File Ref: 20/060

16 March 2021

Subject: Draft Mod 14,16, 17 to MP_10_0137 Huntlee NSW

Figure 3 Required APZ for the large lot site

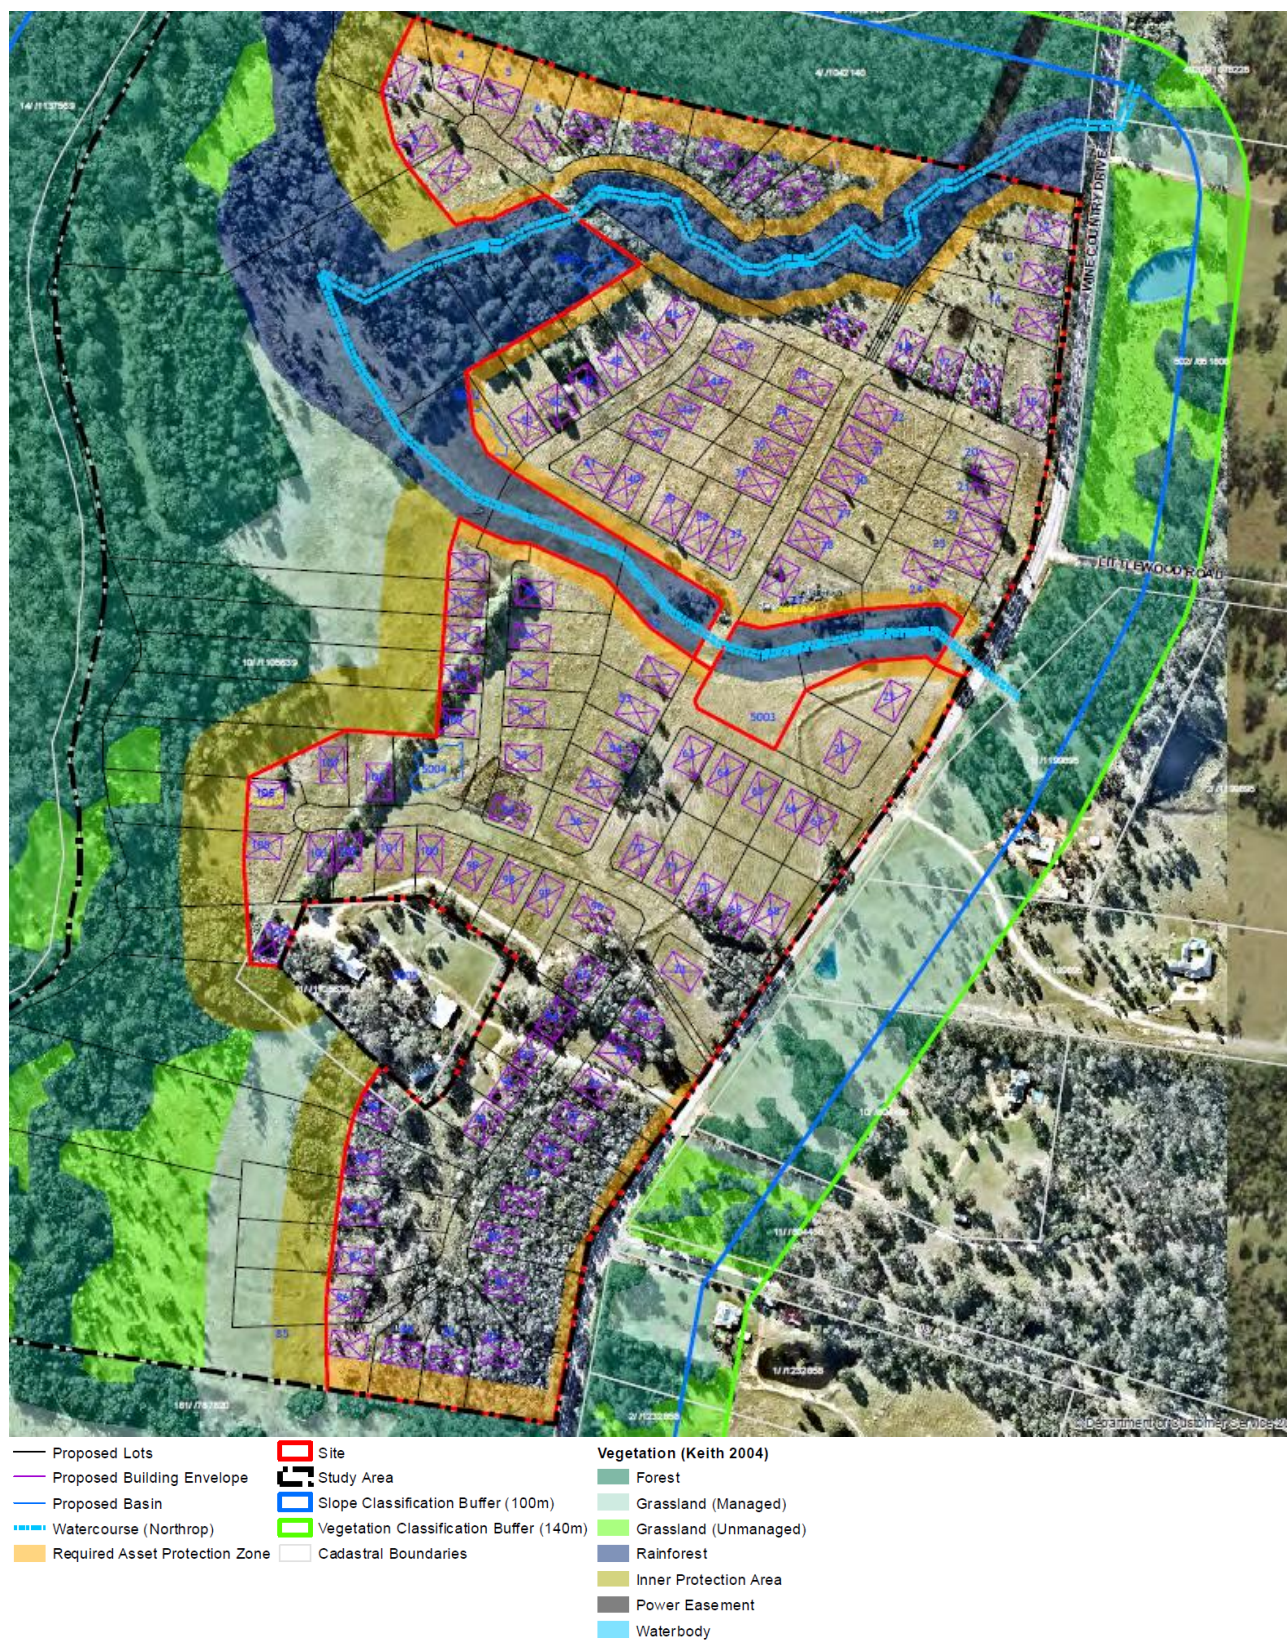
As we have previously extensively investigated this site, we are also concerned that the existing previous EEC on the south eastern corner has not been recognised. In addition, setbacks to Lot 4 DP 1042140 do not appear to reflect current requirements in relation to the bushfire mitigation measures in that there is no perimeter road, and this land will remain an environmental offset reserve with high potential for bushfire.

DRAWING TITLE: **1 TO 3000(MOD14)**
 PROJECT: **HUNTLEE STAGE 1 - DEVELOPMENT AREA WINE COUNTRY DRIVE, HUNTLEE**
 CLIENT: **HUNTLEE PTY.LTD.**

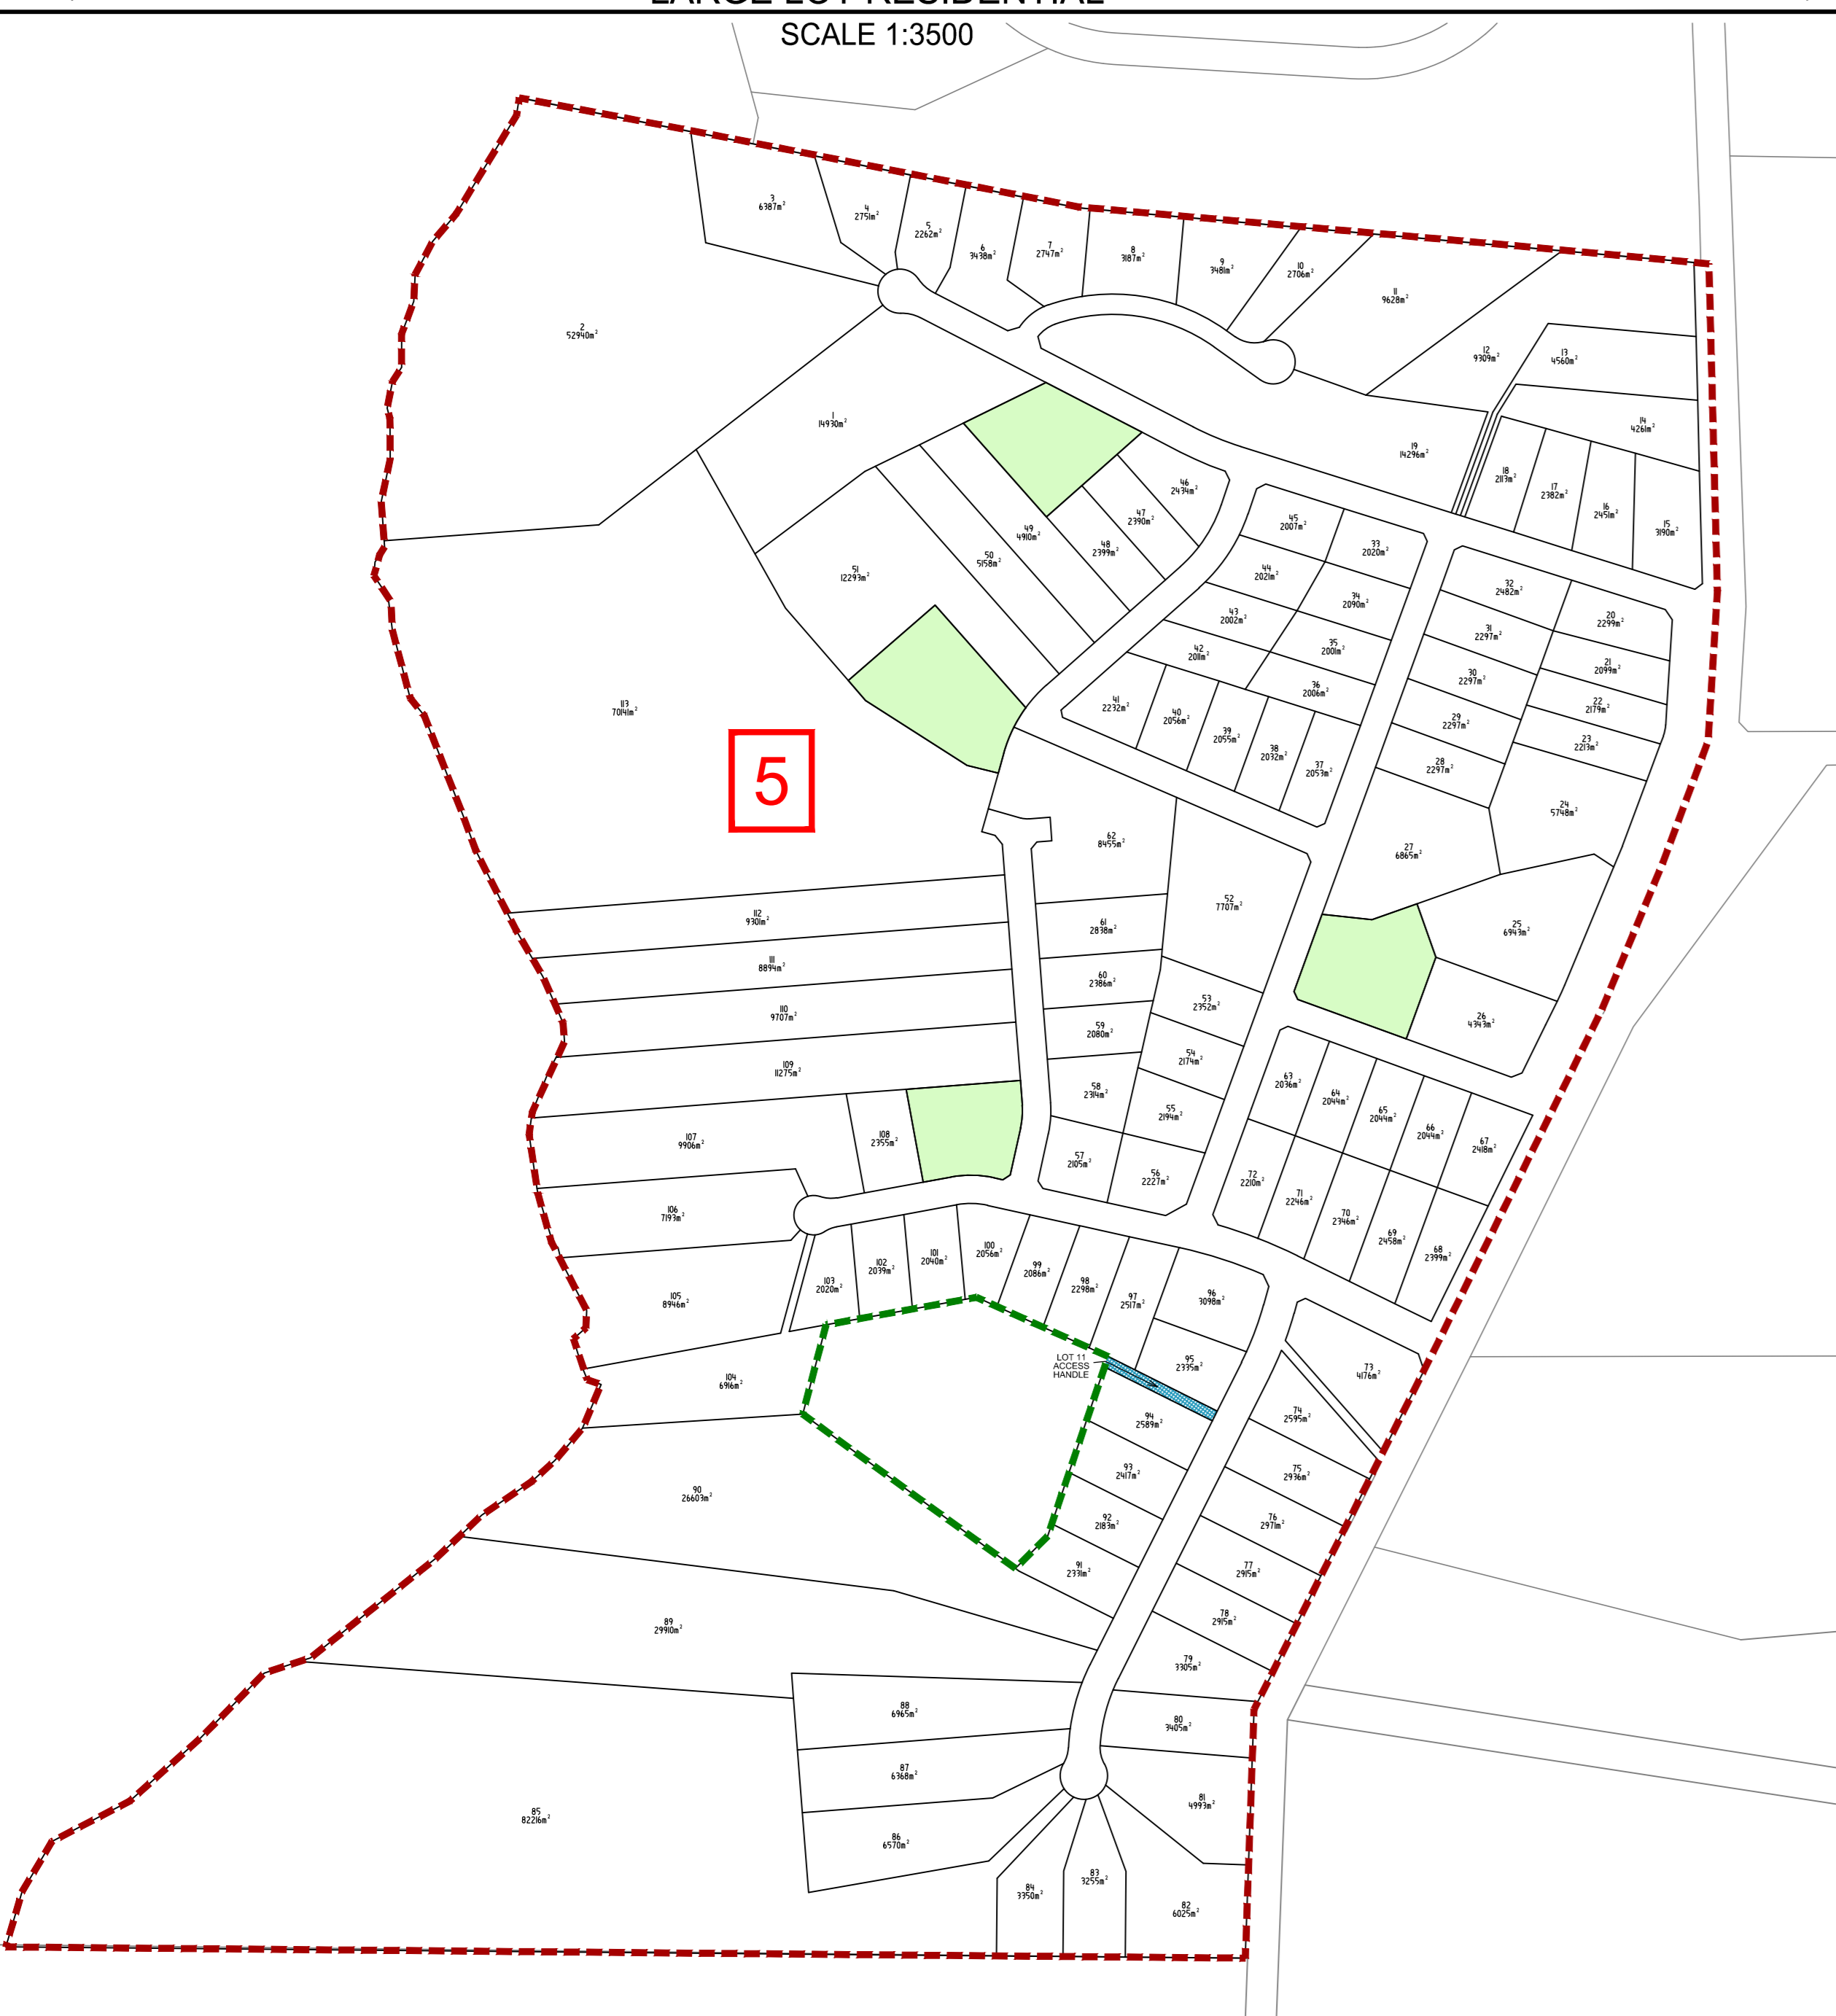
Our client originally owned the whole of this site and sold the large majority of the site to the then owners of the Huntlee Project subject to a Master Plan for the development of this area, which allowed the future development of our clients' residue lot. The limited access proposed by the current design does not allow the development of our clients' lot, and will extinguish this site, contrary to the objectives of the act.

Our main concerns remain the access to Lot 11 which does not meet Council's requirements and should be at least a 16 to 20m wide road reserve.
